Accessibility Design Review

Integrated Acute Services Building (IASB) Addition

Prepared by:	Augustina Lie
Prepared for:	Lendlease
Date:	12 th August 2018
Job No:	75034
Issue:	G

This report forms part of the 50% Schematic Design (SD) review. The report is prepared in relation to the proposed Integrated Acute Services Building (IASB) Addition which is to provide:

LEVEL -01

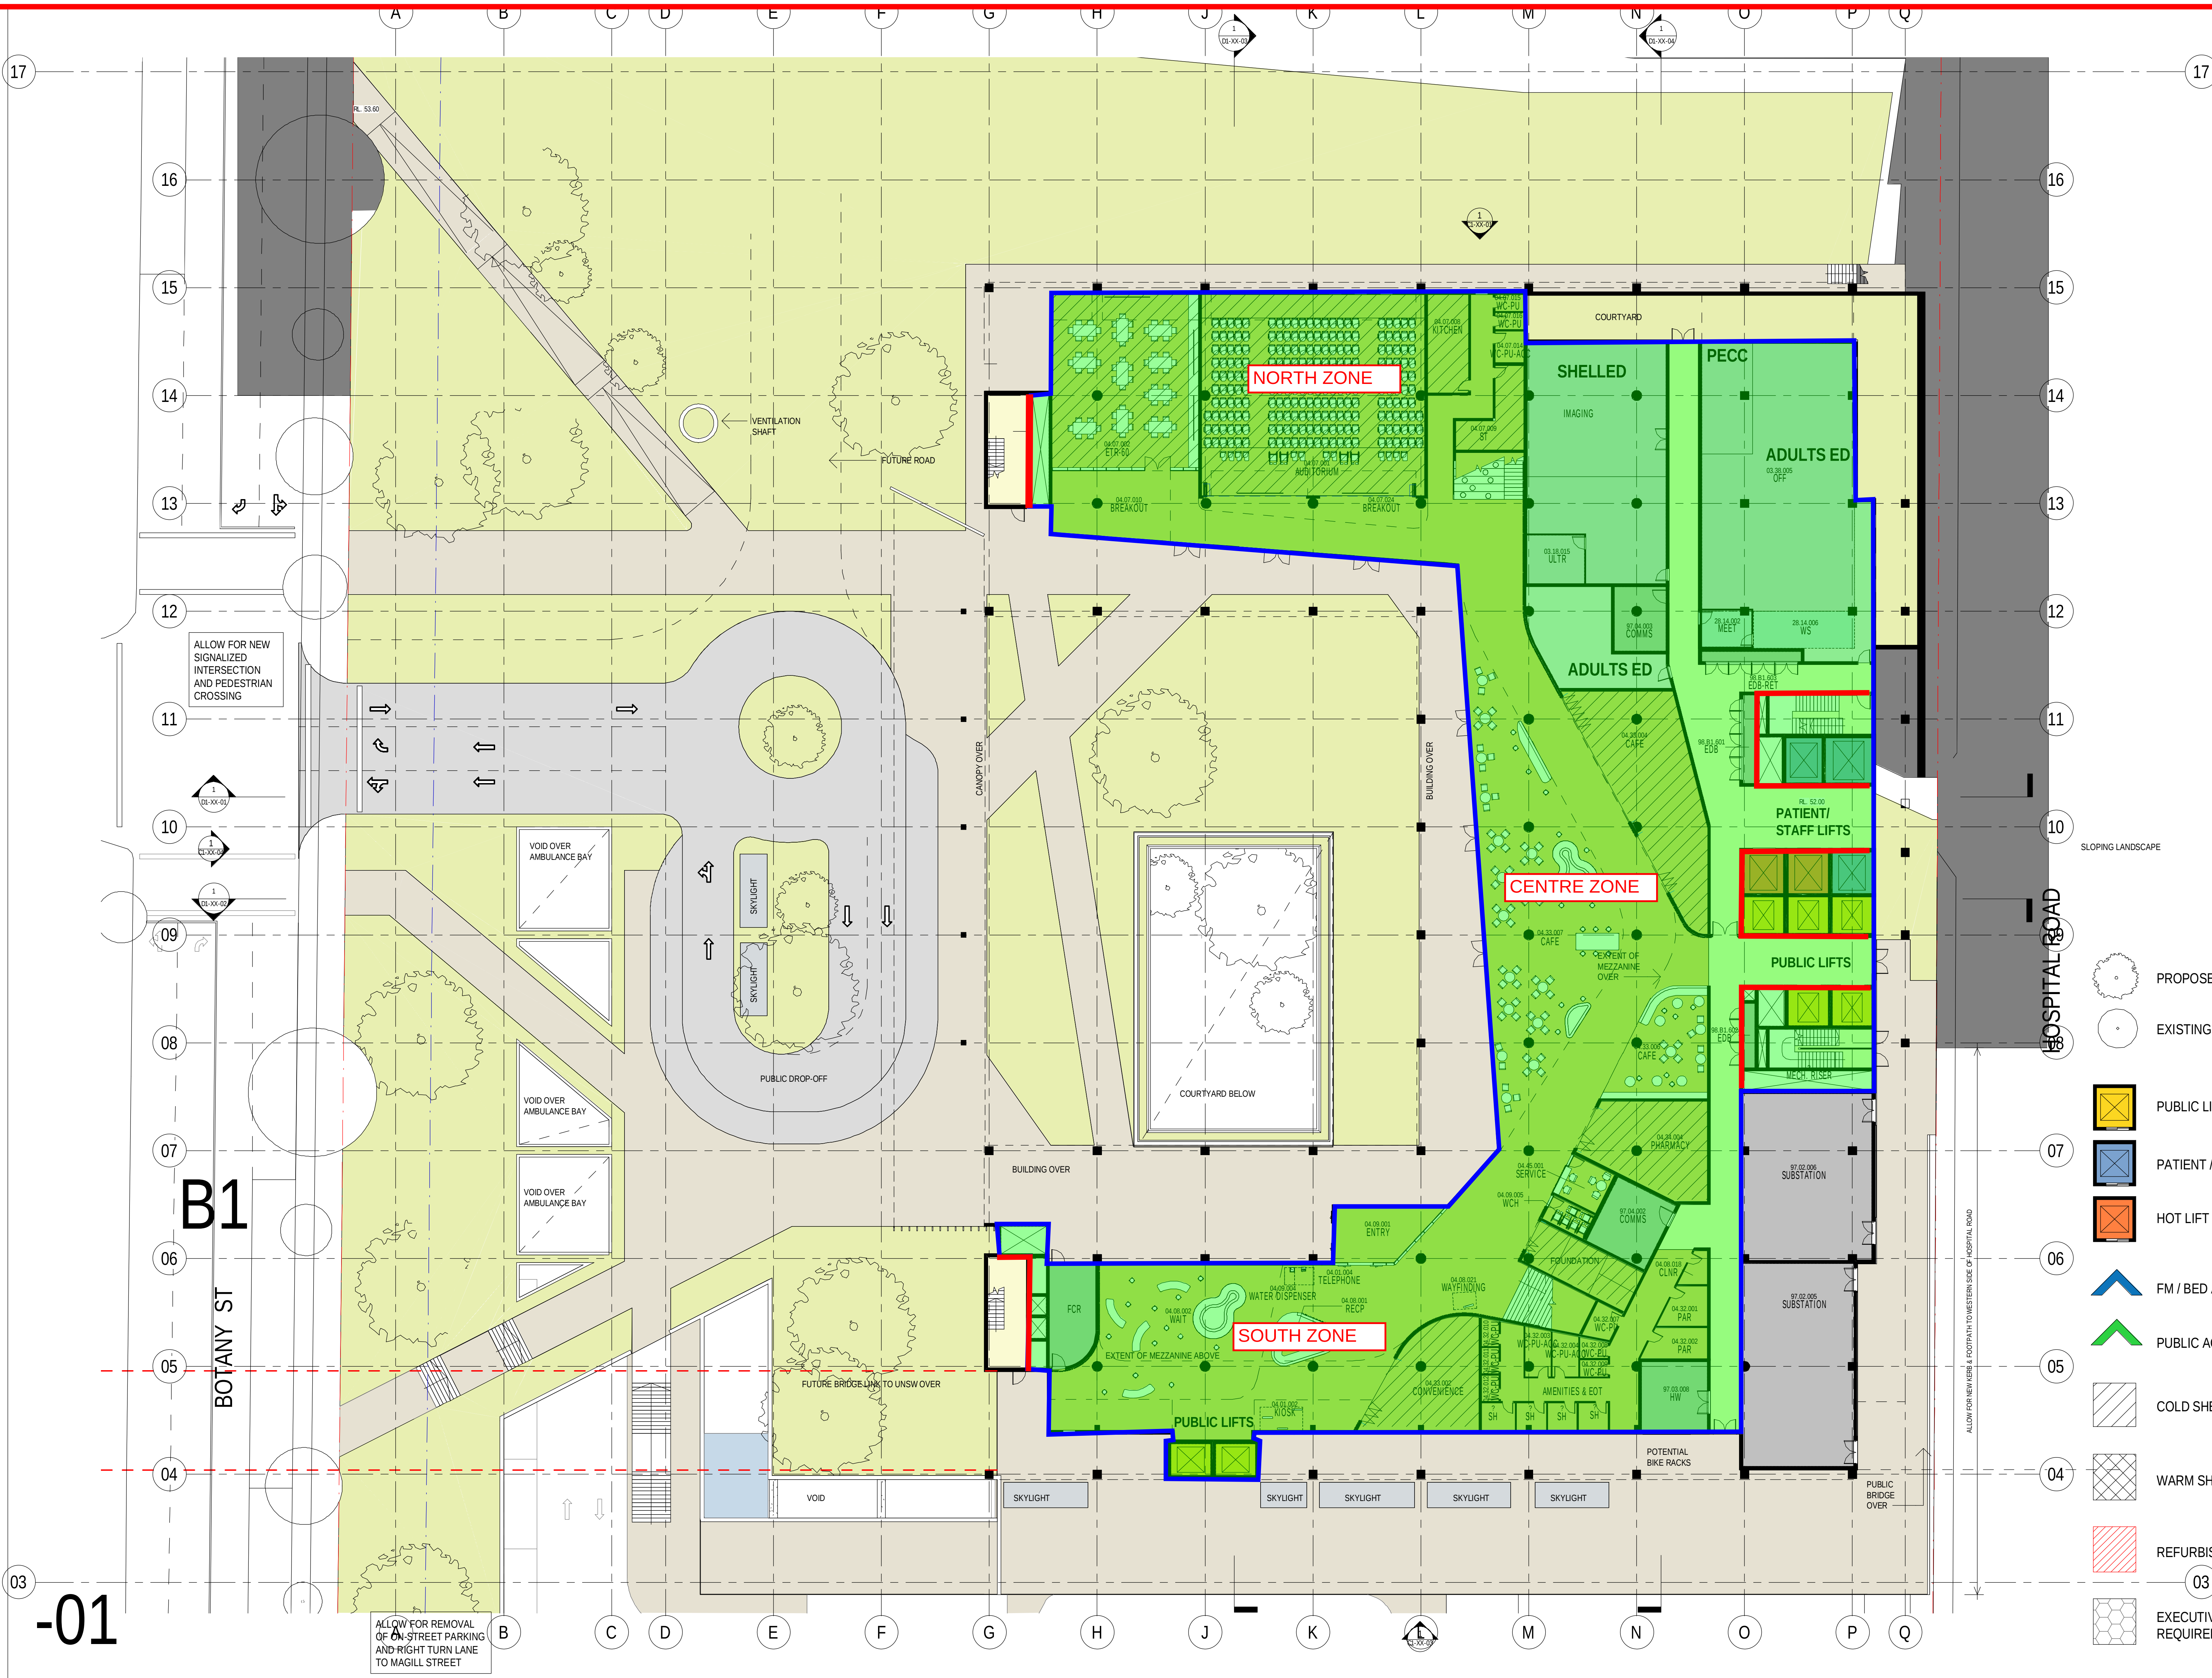
Item	Element	Strategy	Action
1	Service Lane Level (-01) Limited Public Access	<p>Hospital Road is anticipated to be a back-of-house (BOH) laneway servicing deliveries and contractors to the hospital campus</p> <p>It is noted that the lowering of Hospital road will allow 4m clear height to ensure clearance for truck access</p> <p>Level-01 (Hospital Road)</p> <p>Given that Hospital Road is considered to be a back-of-house laneway, the recommended strategies for the provision of public access way are as follows:</p> <ul style="list-style-type: none"> • It is accepted that portions of the walkways may not be wheelchair accessible but may still be used by people with ambulant disabilities or disabilities that do not require the use of a mobility aid. This include: <ul style="list-style-type: none"> ○ General walkway widths of 1200mm clear width in lieu of 1800mm ○ Wheelchair turning spaces ○ Stairways used in lieu of ramps • Public pedestrian access at Hospital Road is provided for locals and staff to ensure safety for all using the laneway. However access from the main points of a pedestrian entry at the allotment boundary is being provided at 	Design to access provision as indicated

<p>Level-00</p> <ul style="list-style-type: none"> • Clear delineation between roadway and walkways are to be provided • Walkways are to be continuous where possible • Walkways may be located on one side of the laneway to minimize pedestrian traversing loading dock entrances • Where the pedestrians are intended to be directed across the road, ensure crossings and appropriate safety signage are provided 	
2	Public Walkway Accessible areas	<p>Level-01 (Sydney Children’s Hospital) It is noted that the design maintains pedestrian access along Hospital Road to the Ainsworth Building to ensure:</p> <ul style="list-style-type: none"> • Accessible parking and drop off is maintained • Logistic access to the equipment store is maintained <p>Level-00 (Public Deck) It is proposed that limited vehicular access is intended on this level This is considered to be the main pedestrian accessway from the allotment boundary and is anticipated that public areas will be located</p>	Design to indicate compliance

GENERAL ARRANGEMENT - LEVEL 00
RCR-BVN-AR-50-DWG-
B2-00-01
ISSUE
T

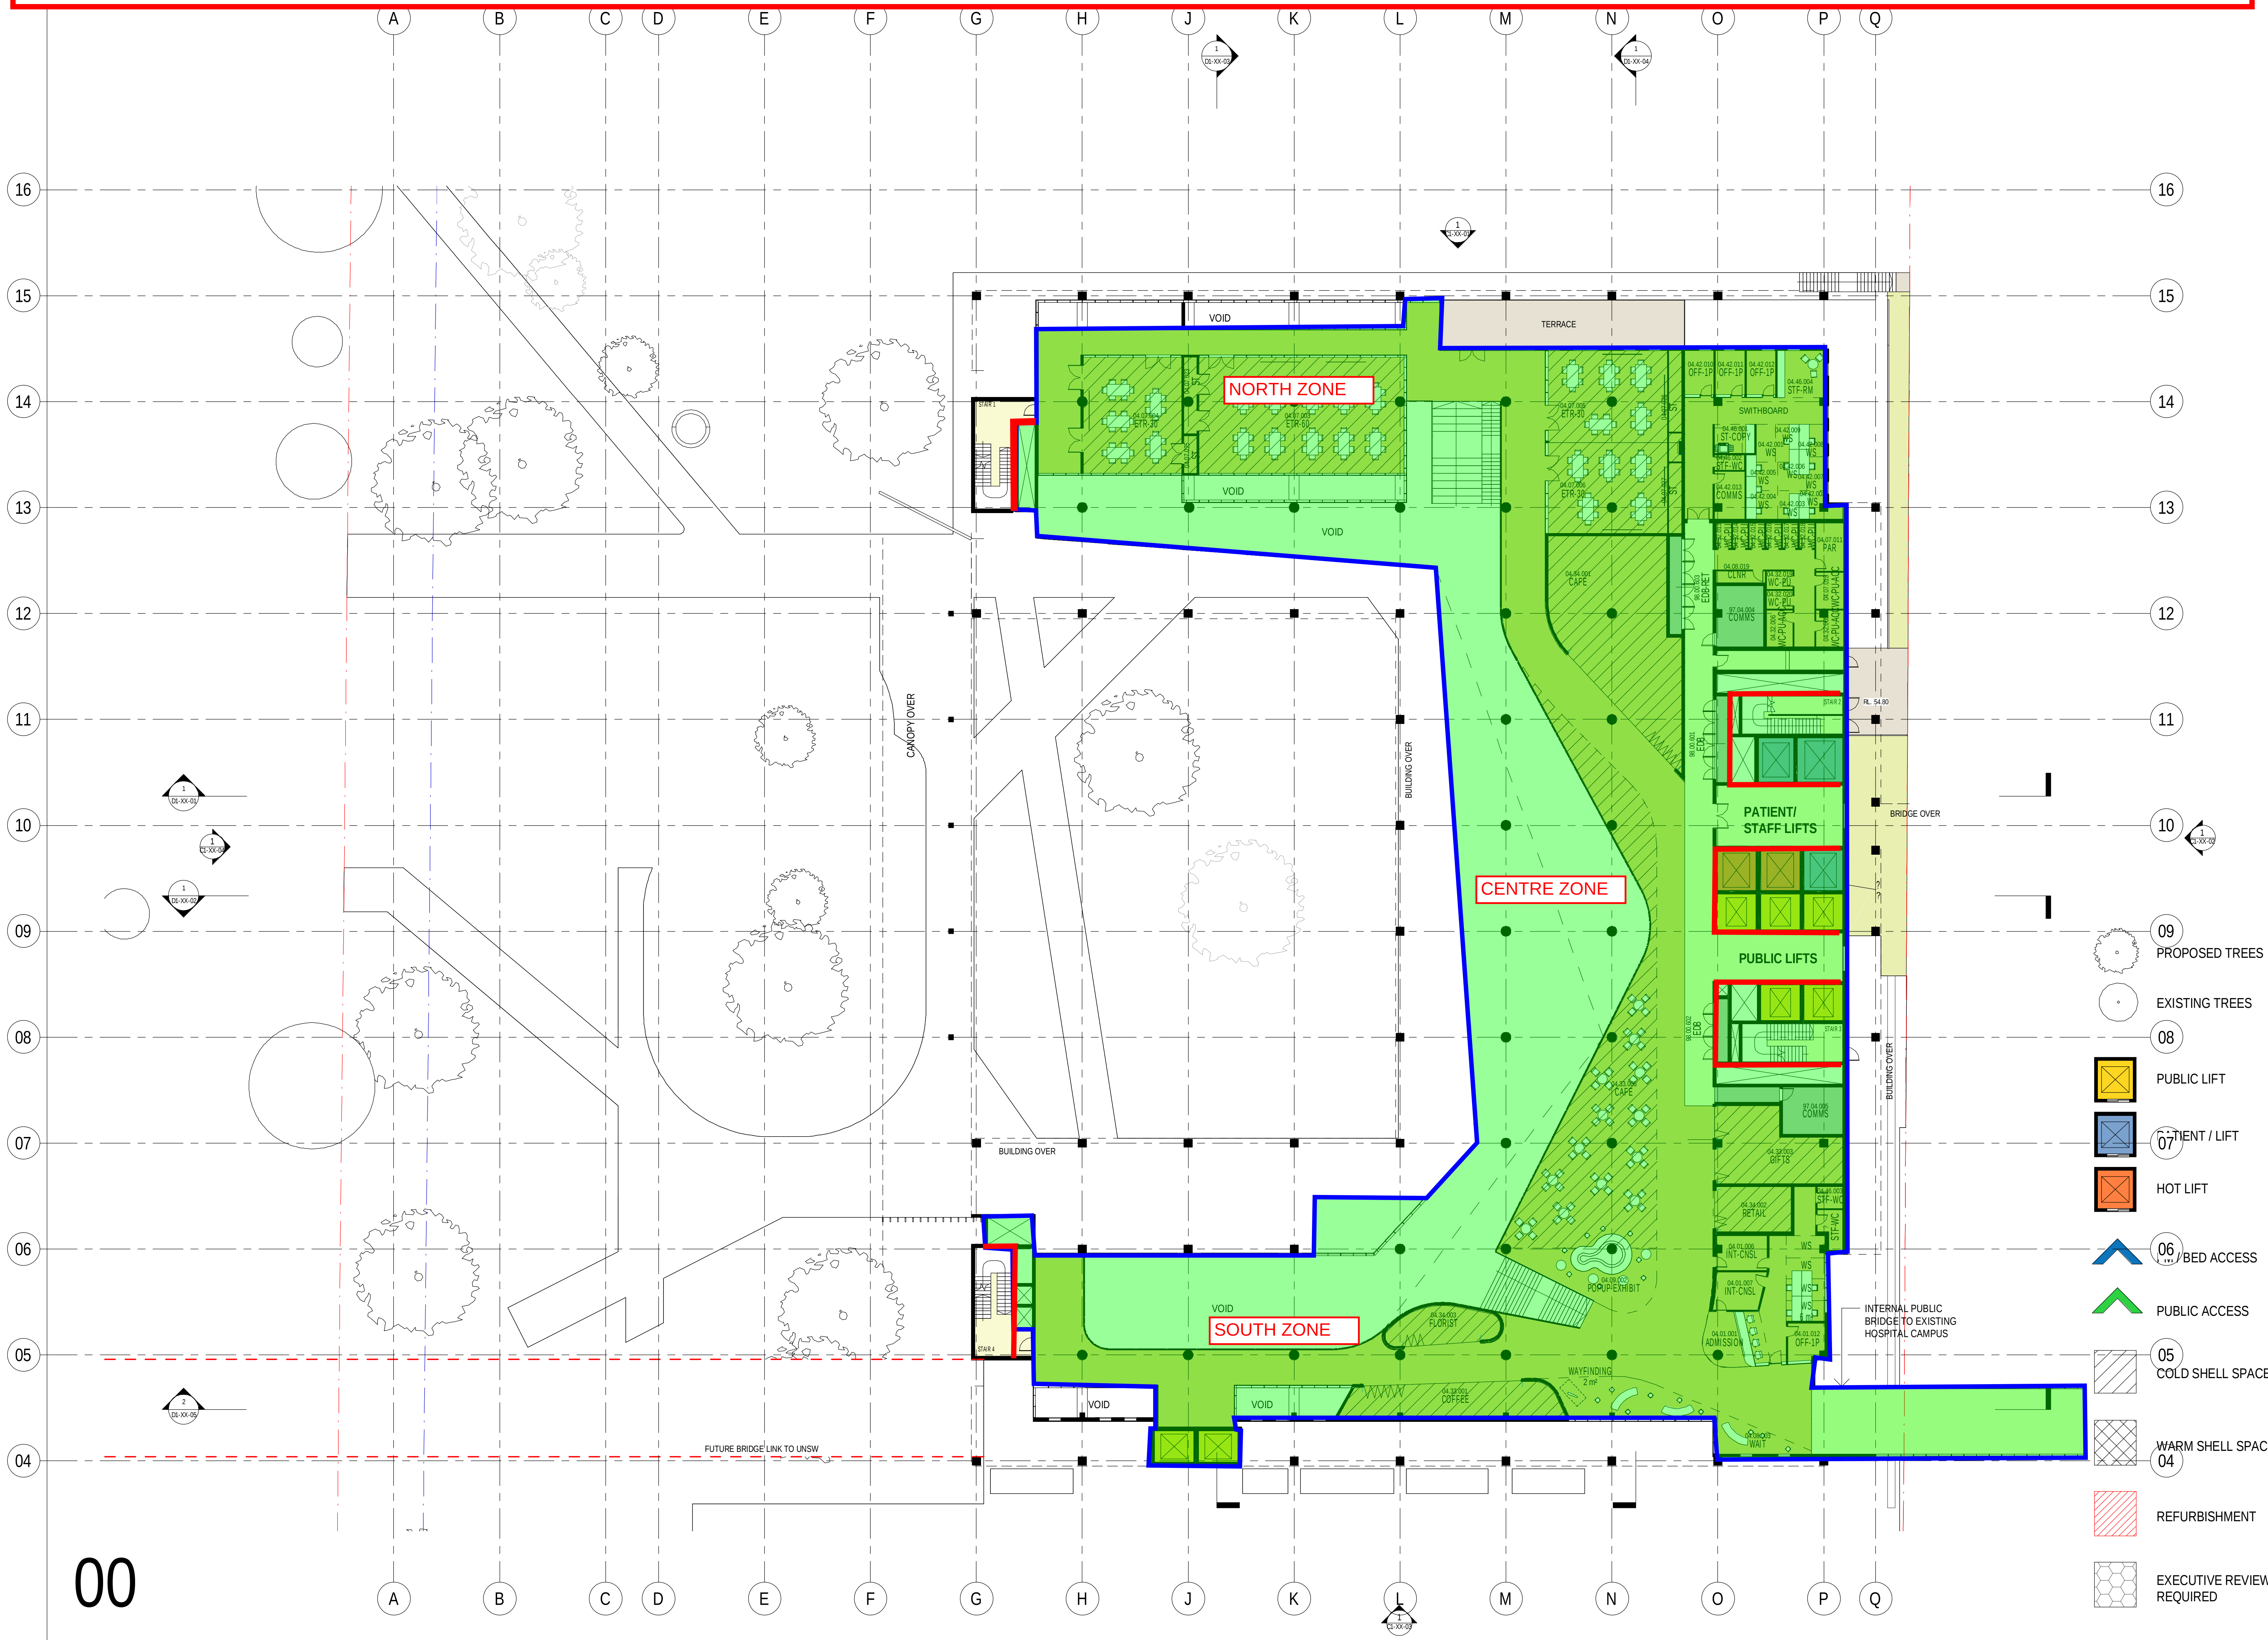
Comment/issue	Recommendation	BCA/ DDA
Corridors	<ul style="list-style-type: none"> ▪ In general, corridors have been detailed with a width in excess of 2000mm which accommodates turning spaces, corridor terminations and passing bays as required. ▪ It is acknowledged that fitout works to be provided by others 	BCA
Corridor Handrails In accordance with Clause D2.17(b)(i) of the BCA, in a class 9a (Hospital) health care building, handrails must be provided along at least one side of every passageway or corridor used by patients and must be: <ol style="list-style-type: none"> a) Fixed not less than 50mm clear of the wall b) Where practicable, continuous for their full length 	The IASB Addition (UNSW Eastern Extension) intended to be for clinical use – Corridor handrails are not required to be provided Level 00: Clinical Innovation Research Space Level 01: Clinical Translation Lab Space Level 02: Clinical Translation Lab Space Level 03: Bioengineering Innovation Space Level 04: Bioengineering Innovation Space Level 05: Education and Research Space Level 06: Education and Research Space Level 07: Education and Research Space Level 08: Education and Research Space Level 09: Plant	BCA
